From: Laura Gibbons <Laura.Gibbons@arun.gov.uk>
Sent: 22 March 2022 15:56
To: Planning.Responses <Planning.Responses@arun.gov.uk>
Cc: Simon Davis <Simon.Davis@arun.gov.uk>
Subject: RE: Planning Consultation on: AL/28/22/DOC

Engineers Comments Regarding Condition 10

Application No: AL/28/22/DOC
Registered: 3rd March 2022
Site Address: Land At Wings Nursery Lidsey Road Woodgate PO20 3SU
Description of Works: Approval of details reserved by condition imposed under AL/20/21/PL relating to condition 10-surface water drainage.

AQUACELL SURFACE WATER STORAGE TANK
(Scale 1:20)

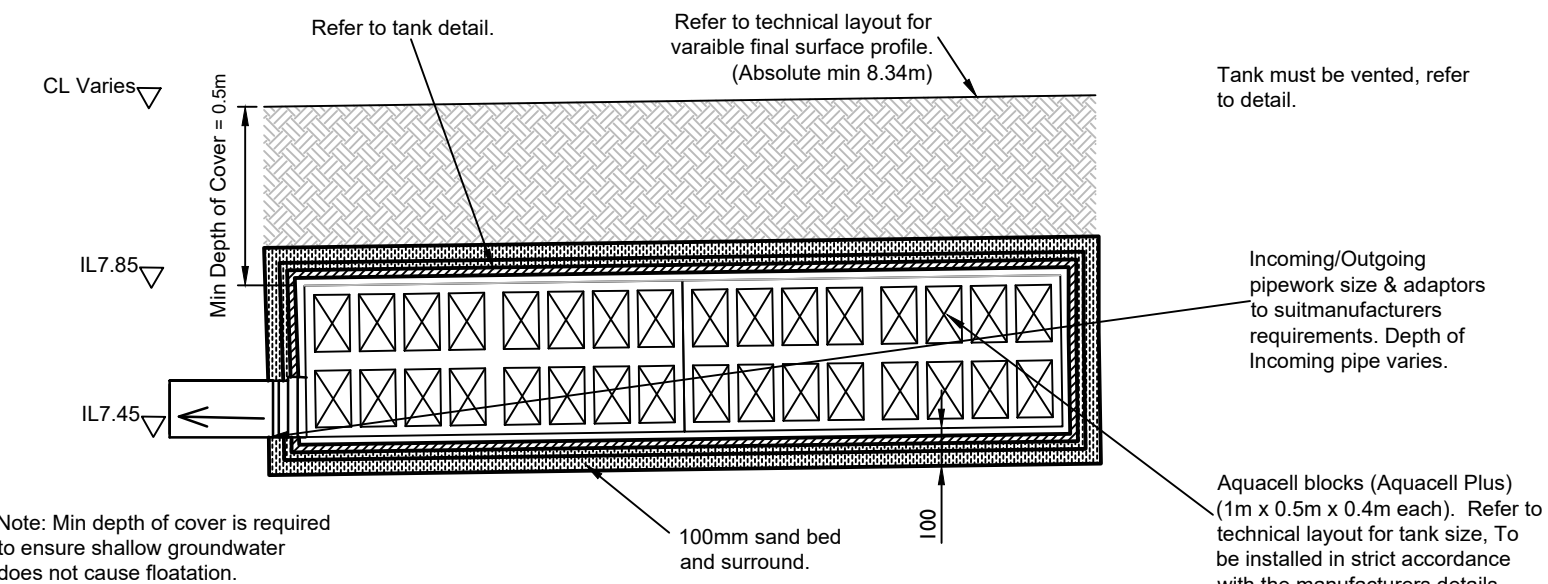
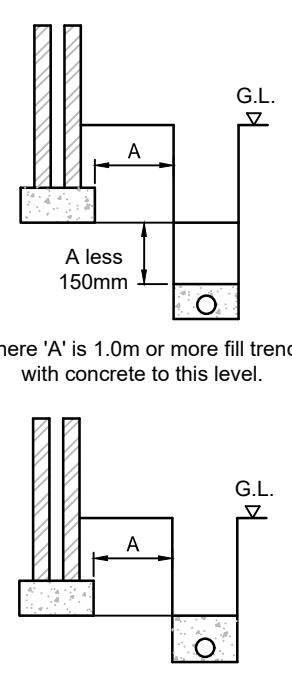
15. Please detail membrane around attenuation tank on construction detail drawing. Please make detail site specific.
16. Please provide construction detail drawings of permeable paving.
17. Please provide two perpendicular cross sections of the basin, please detail liner, topsoil depths, etc. on construction detail drawing.
18. For the bagwork headwalls to the basin- please detail bag size, how full bags are to be with ST4 concrete, how bags are to be compacted, what bond pattern is to be followed, spacing of pins, minimum width of headwalls, etc.

PLAN
FLOW CONTROL CHAMBER S102
(Scale 1:20)

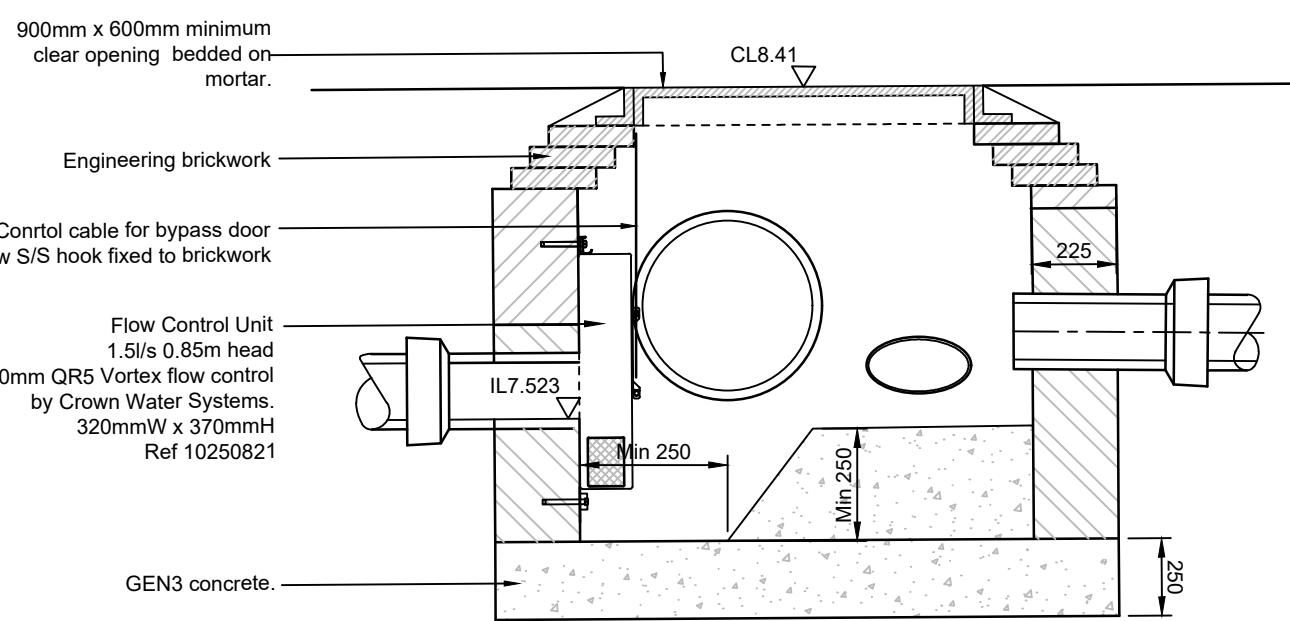
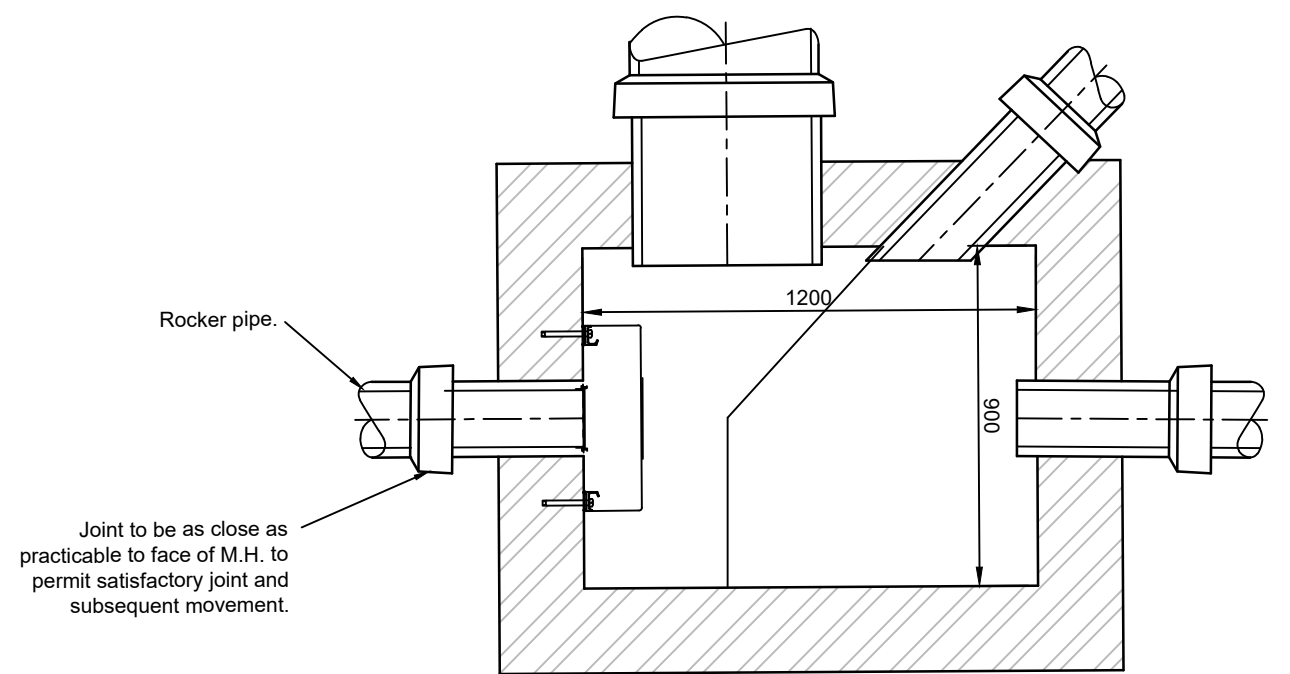
12. Please provide flotation calculations for cellular storage and attenuation basin.
13. Please provide data sheets to evidence flow control devices for S102 and S23 will achieve the criteria within the flow model.
